Our Ref: EP/18/19/HH
Your Ref:

Town & Country Planning Act 1990 (as amended)
Town & country Planning (Development Management Procedure) (England) Order 2015
Application for Planning Permission for Works or Extension to a Dwelling

Development SINGLE STOREY REAR EXTENSION
Location 21 Warren Crescent East Preston

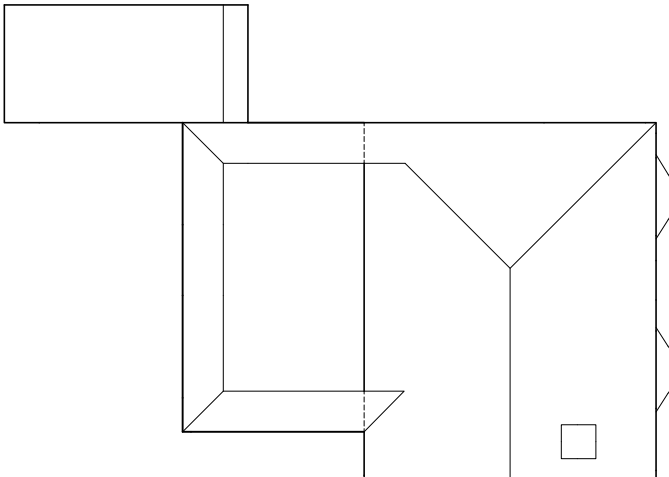
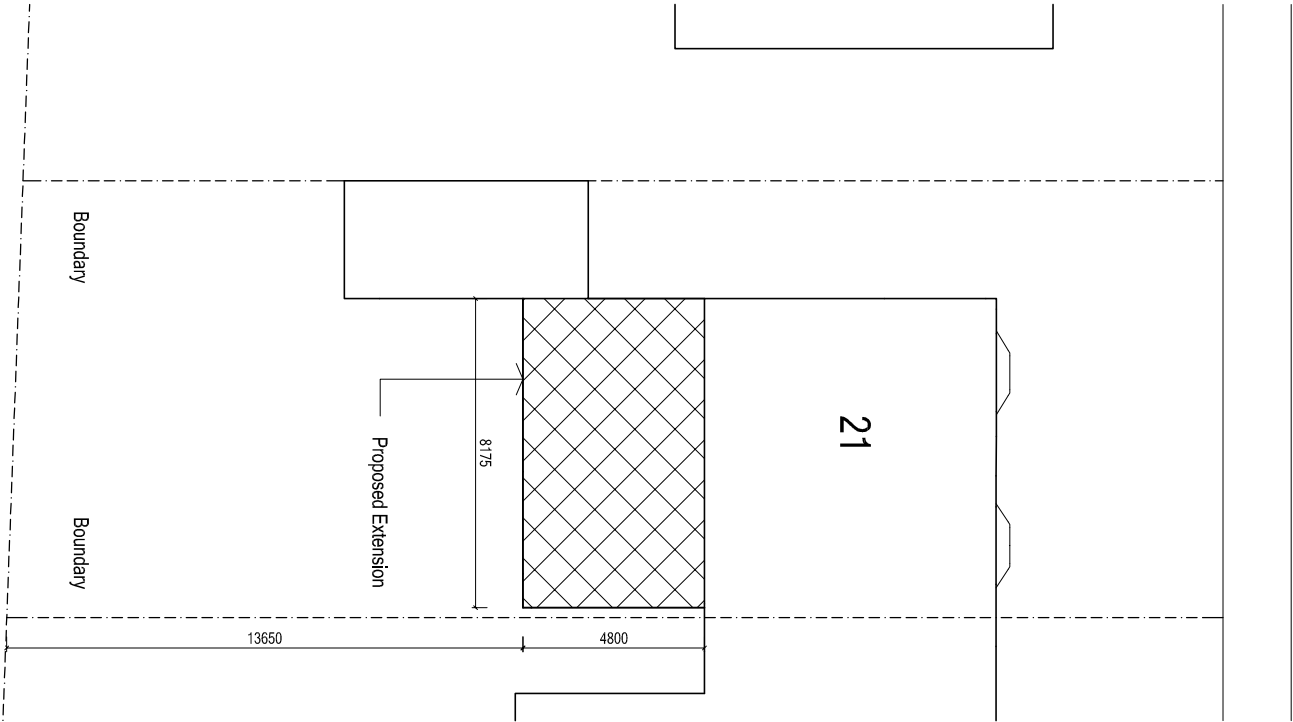
Block Plan

Please submit 1 electronic or 3 paper copies of a block/site which includes a dimension from the proposed extension to the rear boundary. Further details of what must be included on the plan can be found in the National Validation Requirements.
